Subject: Response To Application Number WA/99/18/DOC at Land east of, Tye Lane, Walberton, Arundel

TO:	Arun District Council FAO: Michael Eastham
FROM:	Stephen Gee WSCC - Highways Authority
DATE:	28 February 2019
LOCATION:	Land east of, Tye Lane, Walberton, Arundel
SUBJECT:	WA/99/18/DOC Application for approval of details reserved by conditions imposed on planning reference WA/44/17/OUT relating to conditions 5, 9, 10, 11, 12 13, 16, 17, 24, 25, 27, 28, 30, 32, 33, 36, 41, 42 and 43. More information
DATE OF SITE VISIT:	
RECOMMENDATION:	No Objection / Objection
S106 CONTRIBUTION TOTAL:	£ See below for breakdown.

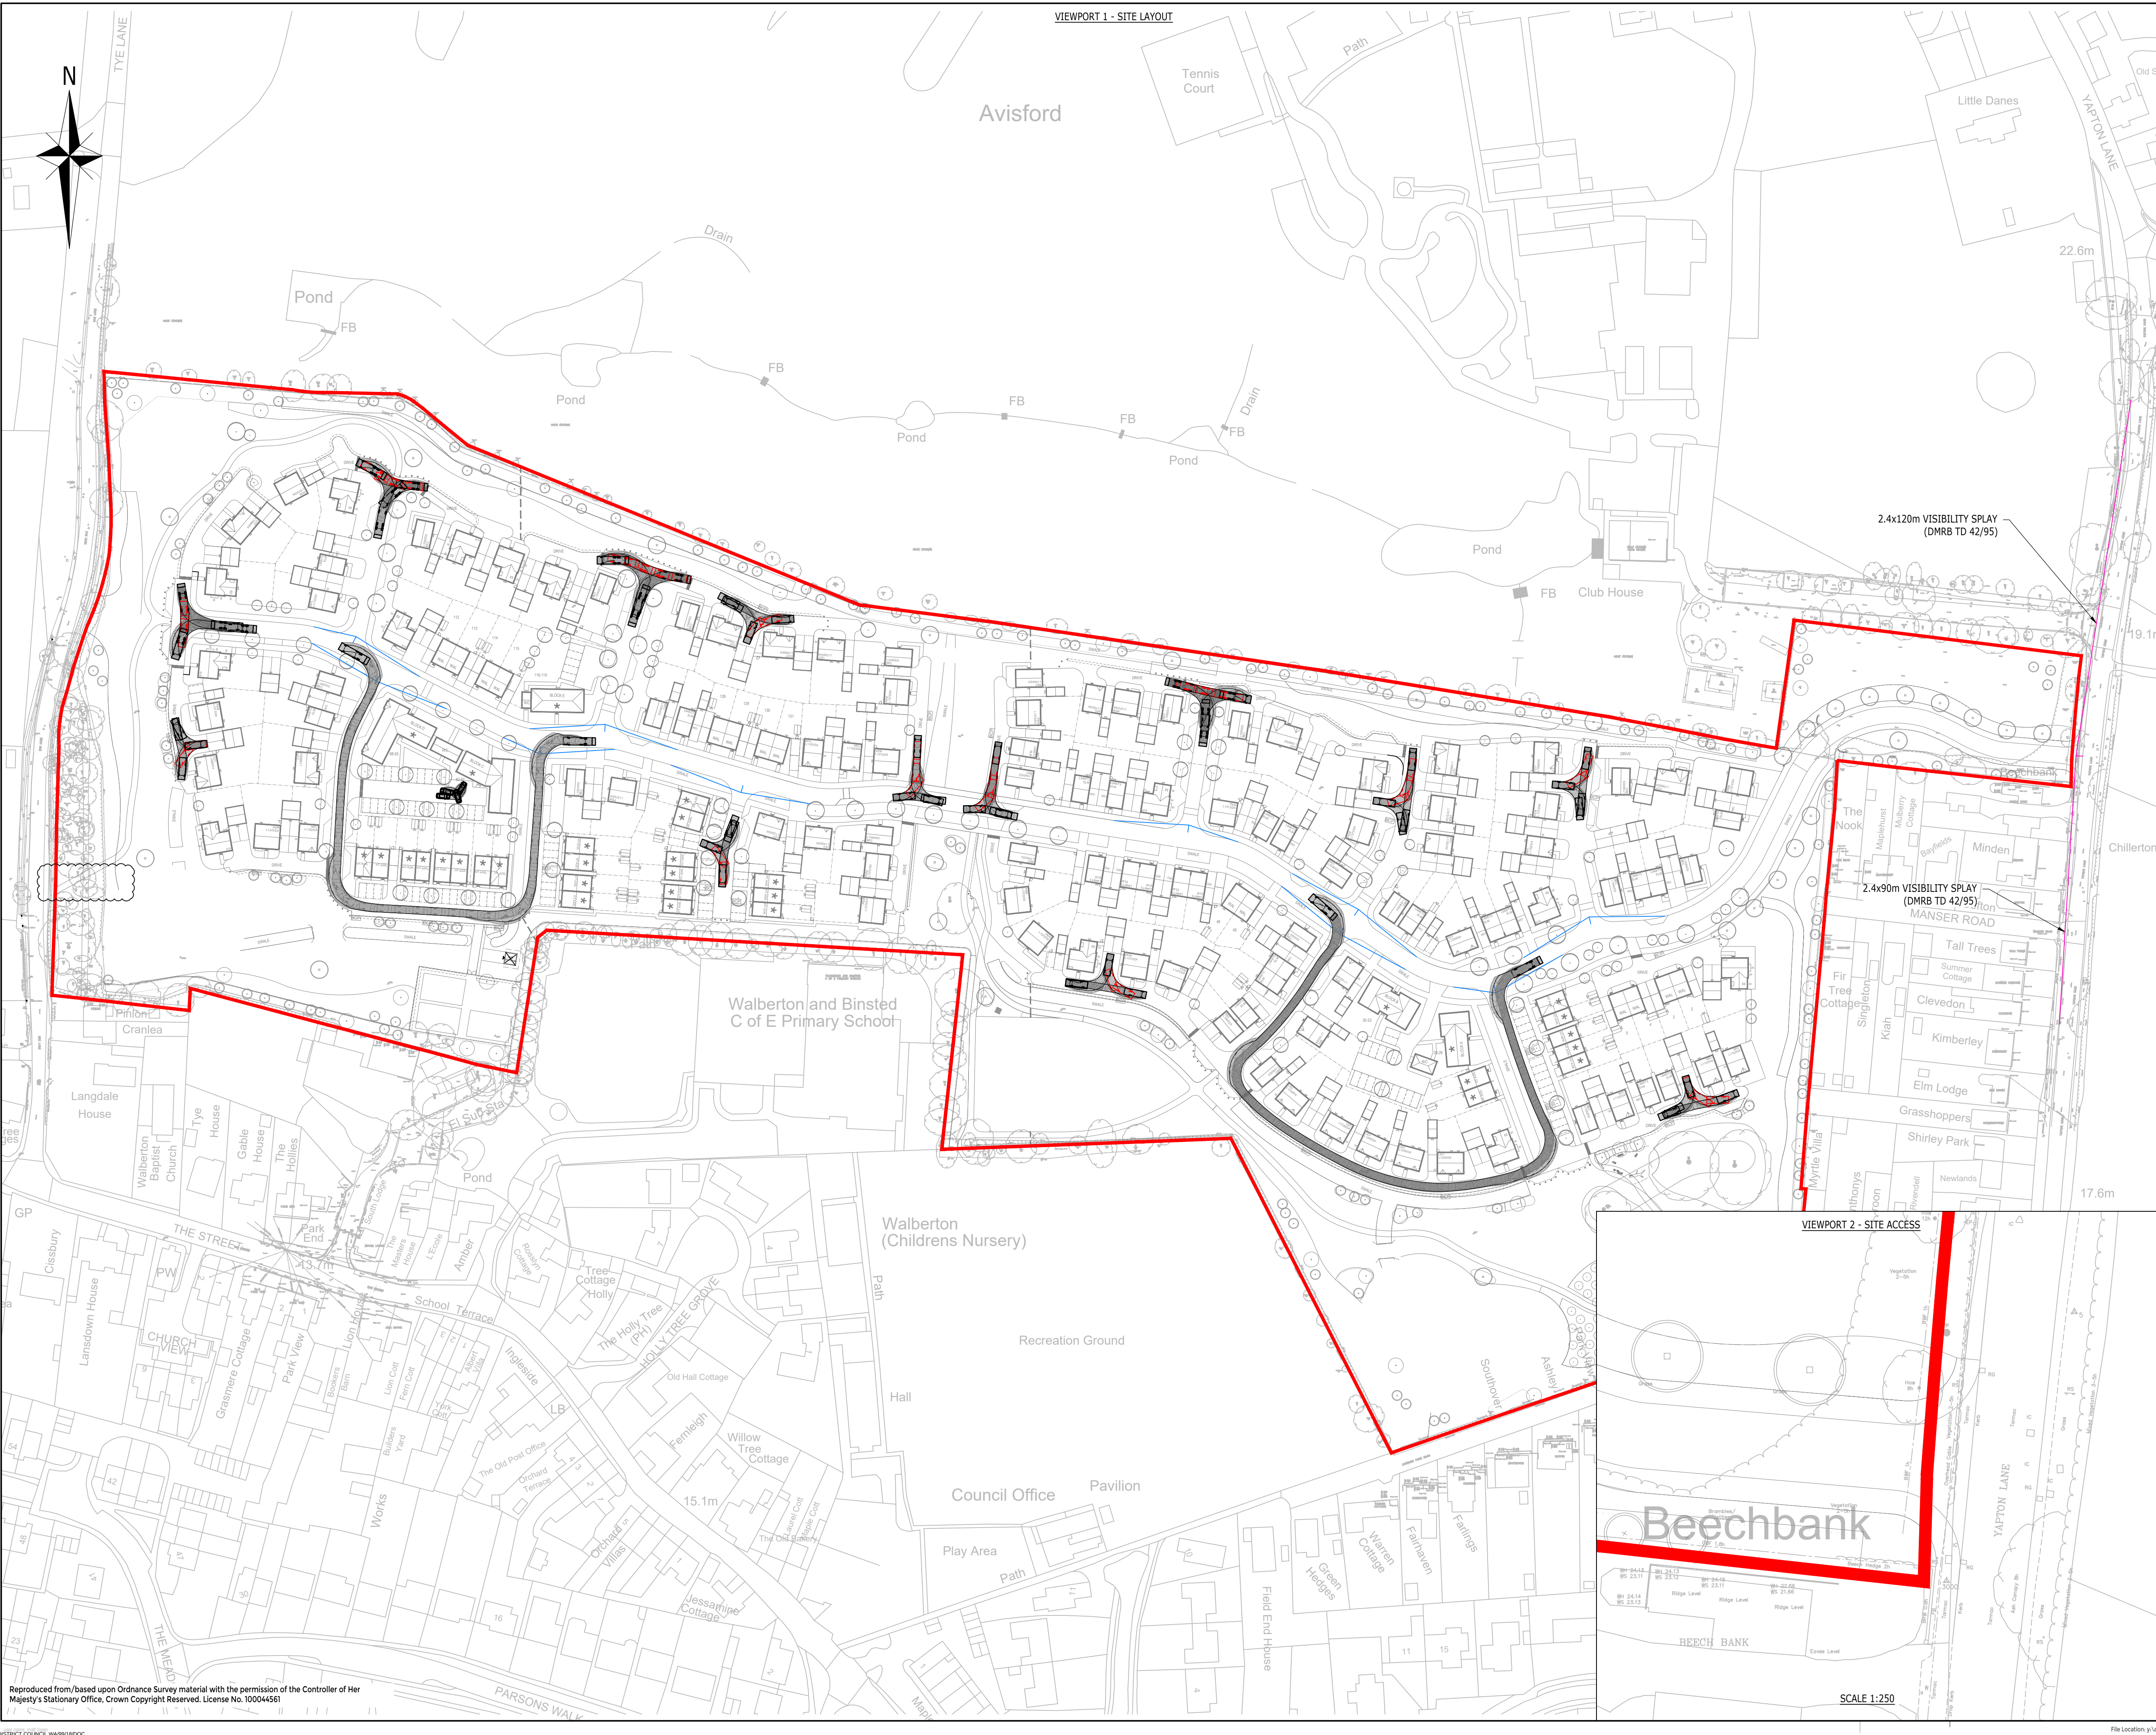
16 – A revised swept path plan has been provided and is accepted. No objection to the discharge of condition.
